Mark Belles
Gaye Belles
13610 Bandanero Drive
Peyton, Colorado 80831

Reference: Meadowlake Ranch Sketch Plan, Project File No. SKP184

We have reviewed the revised Letter of Intent posted on January 7th, 2019 and the revised Sketch Plan posted on January 14th, 2019 at the El Paso County Development Application Review website for this project.

SKETCH PLAN

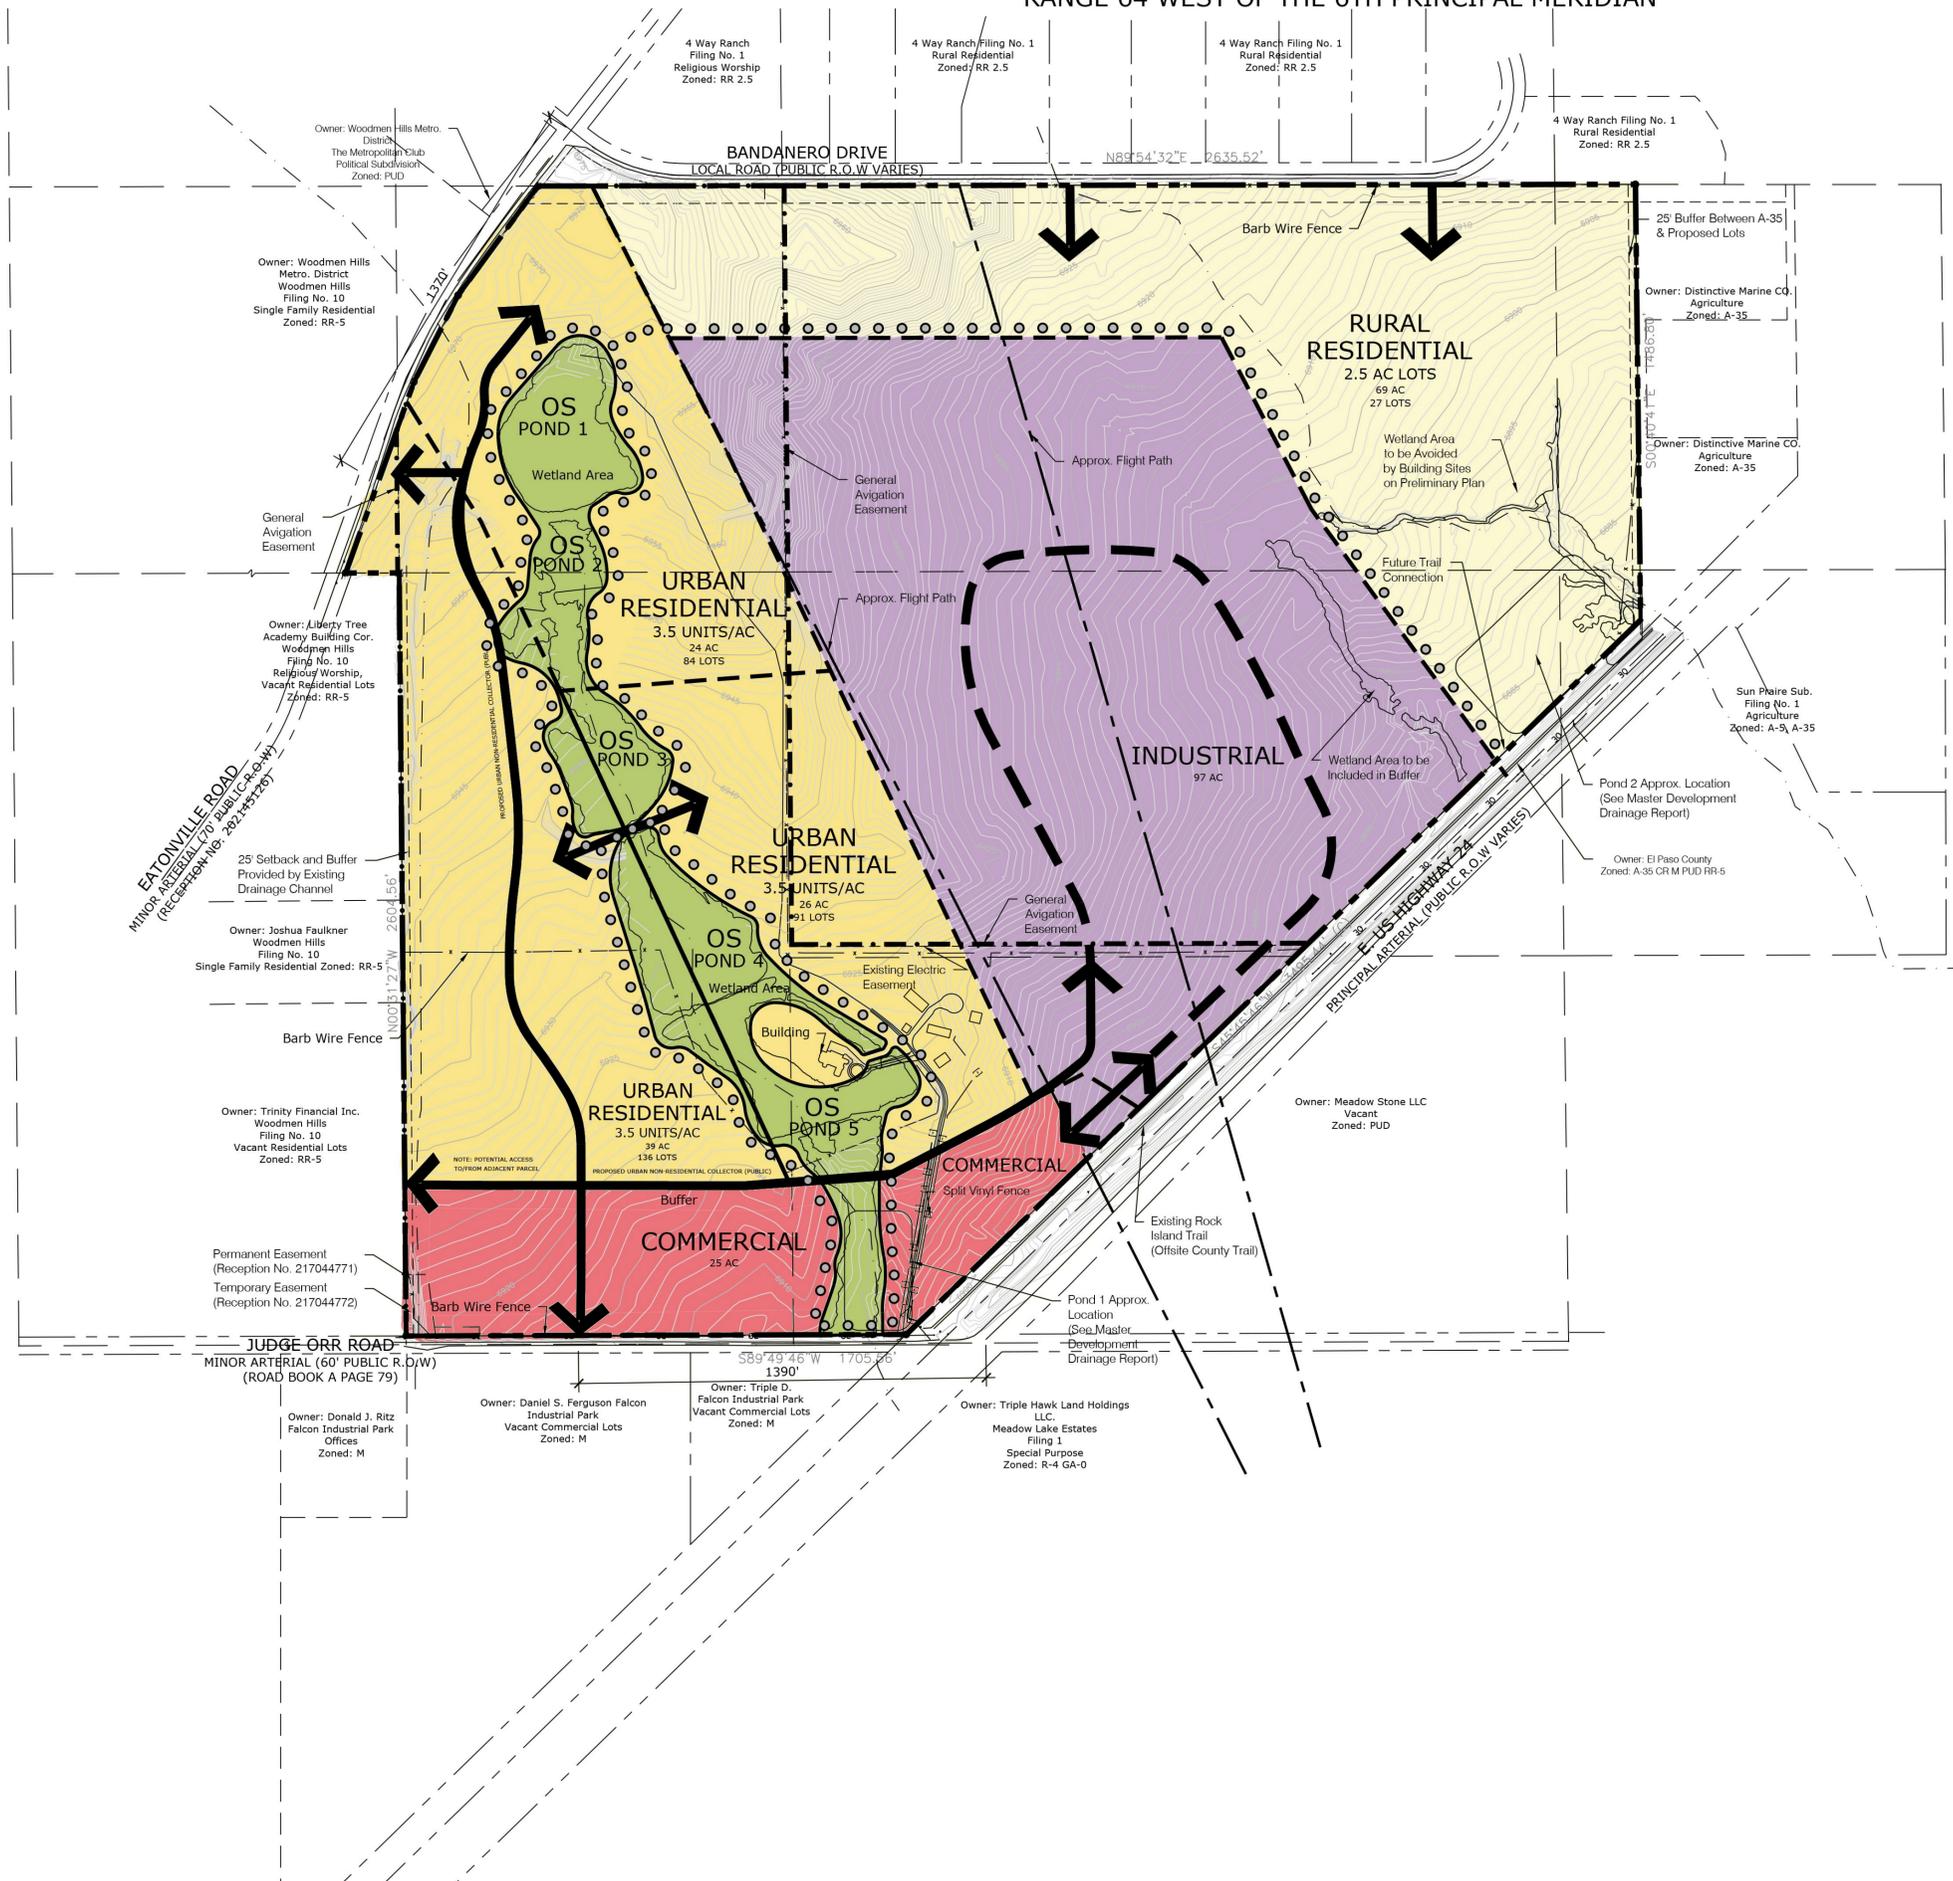
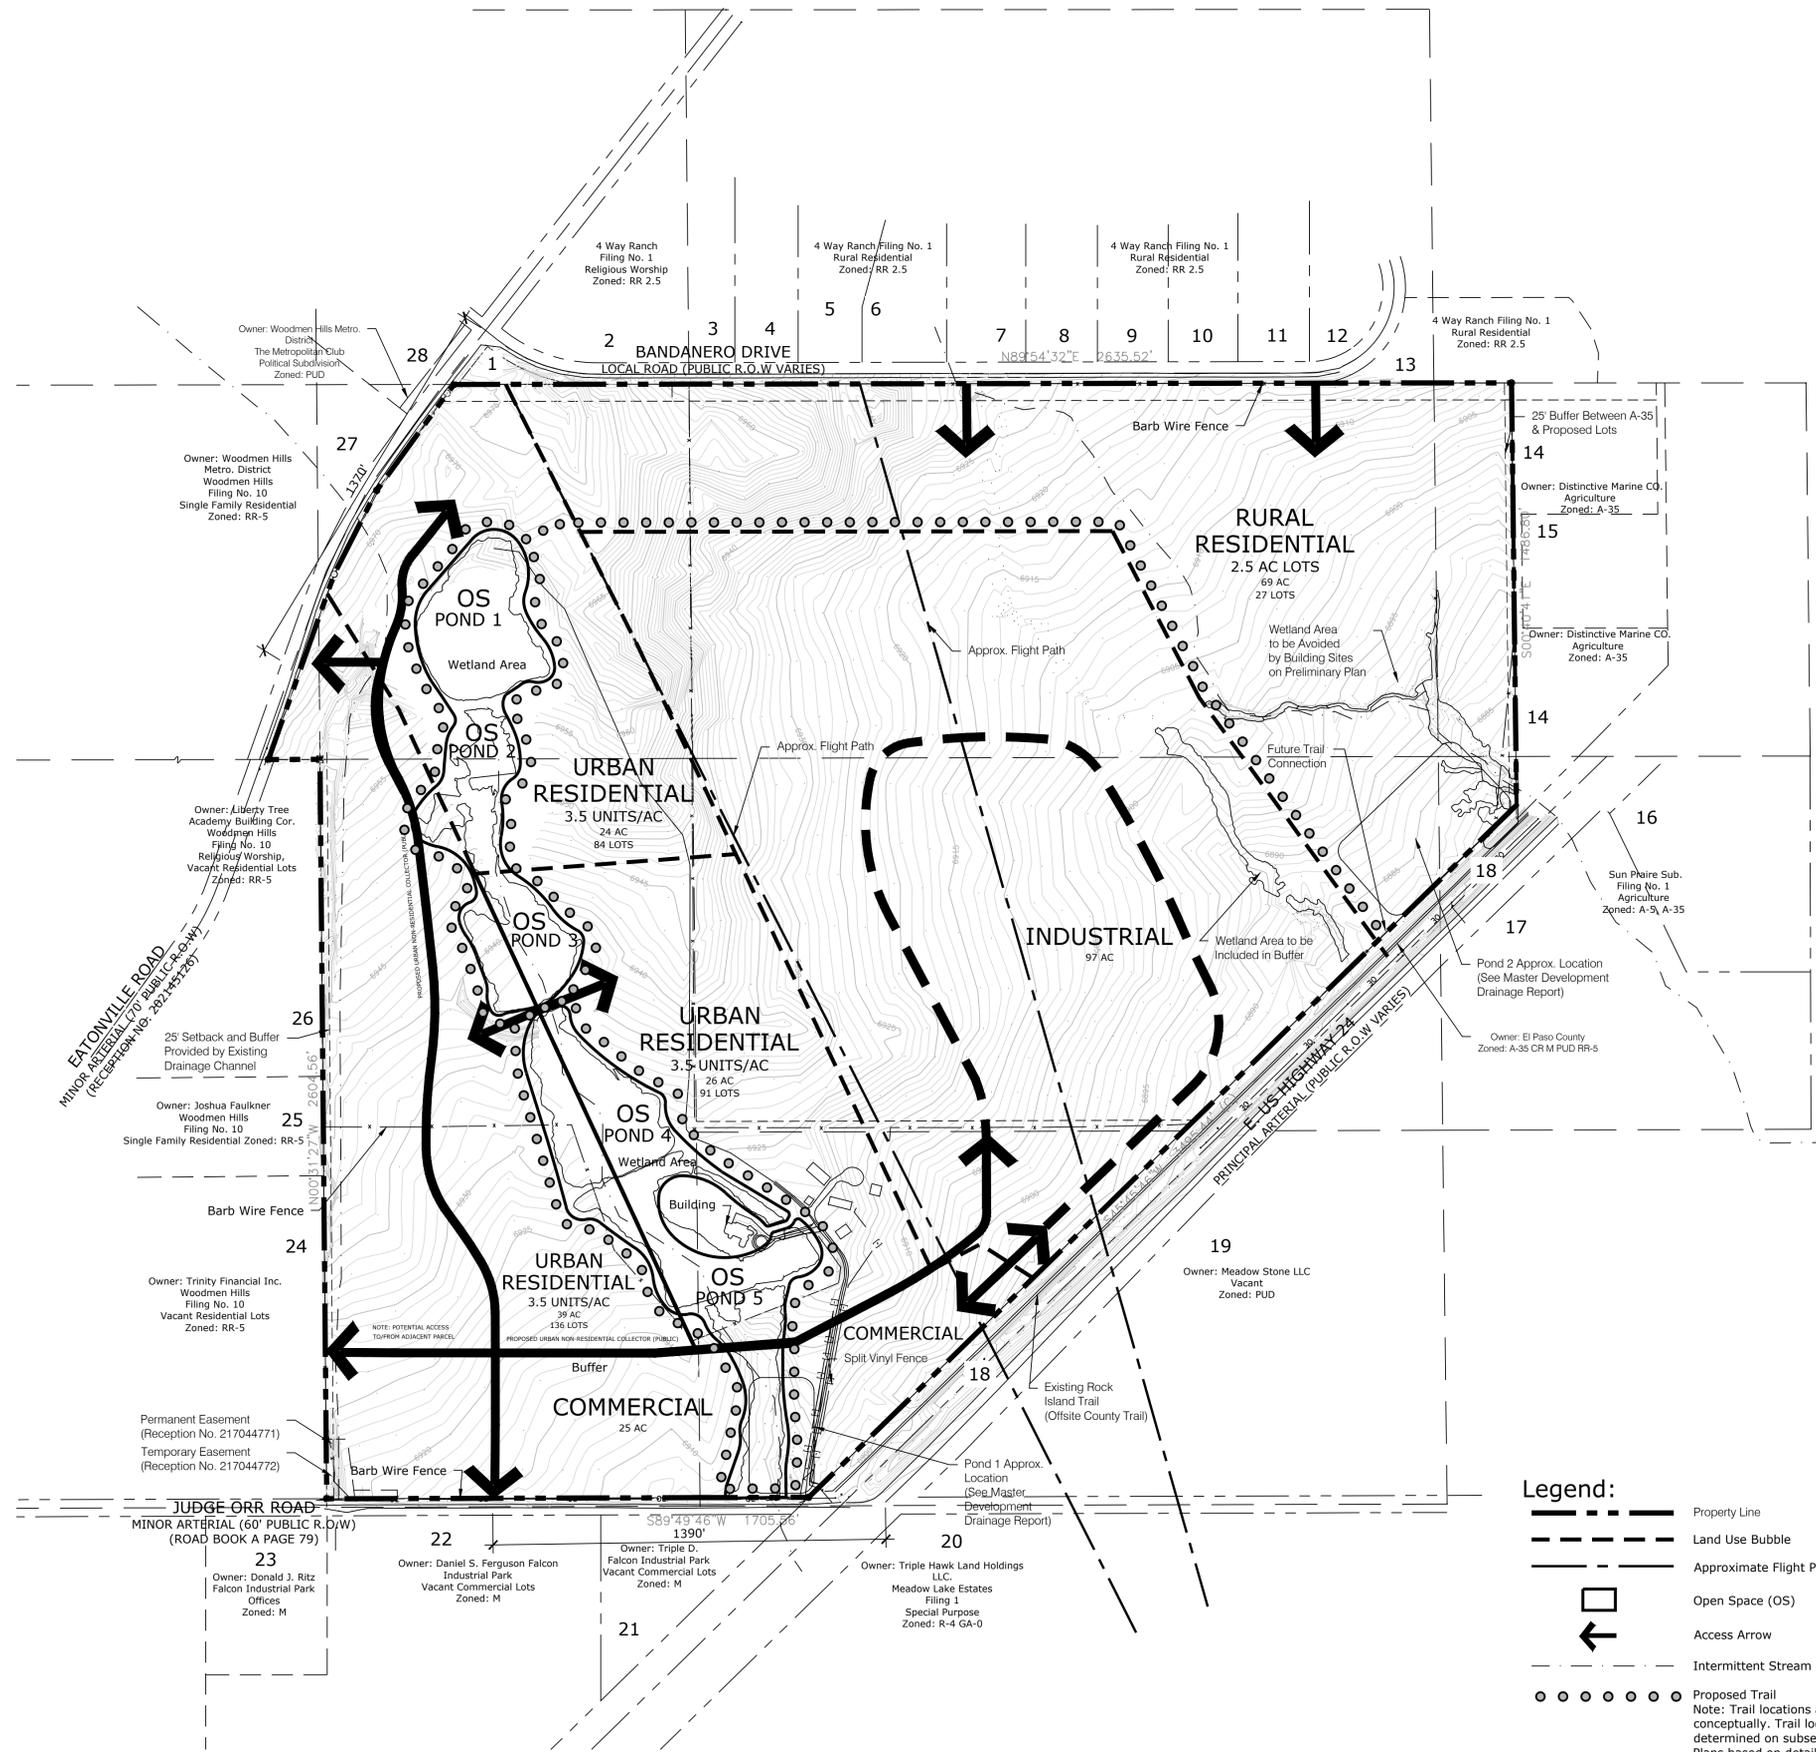
The revised sketch plan expands the proposed Industrial use area in a northerly direction as compared to the previous sketch plan. See Attachments A and B. The sketch plan is drawn to scale and indicates that the boundary of the Industrial use area will be less than 600 feet from properties on the north side of Bandanero Drive. We own and live at one of those properties.

We contend that the quantity of Industrial use area (58 acres or 19% of the development) and the close proximity of proposed Industrial use area to Residential use area not only fails to comply with this plan goal, but actually violates the goal. Contrary to the statement in the Letter of Intent, there are no nearby Industrial uses in either the Woodman Hills or 4-Way Ranch Metropolitan Districts No. 1.

We contend that the close proximity of proposed Industrial use area to Residential use area not only fails to comply with this plan goal, but actually violates the goal. It is not the objective of paragraph 4.5.2.1 to encourage close proximity of Industrial and Residential uses. Mixed non-residential use is normally understood to exclude Industrial use.

We object to the extension of the Industrial use are to the north.
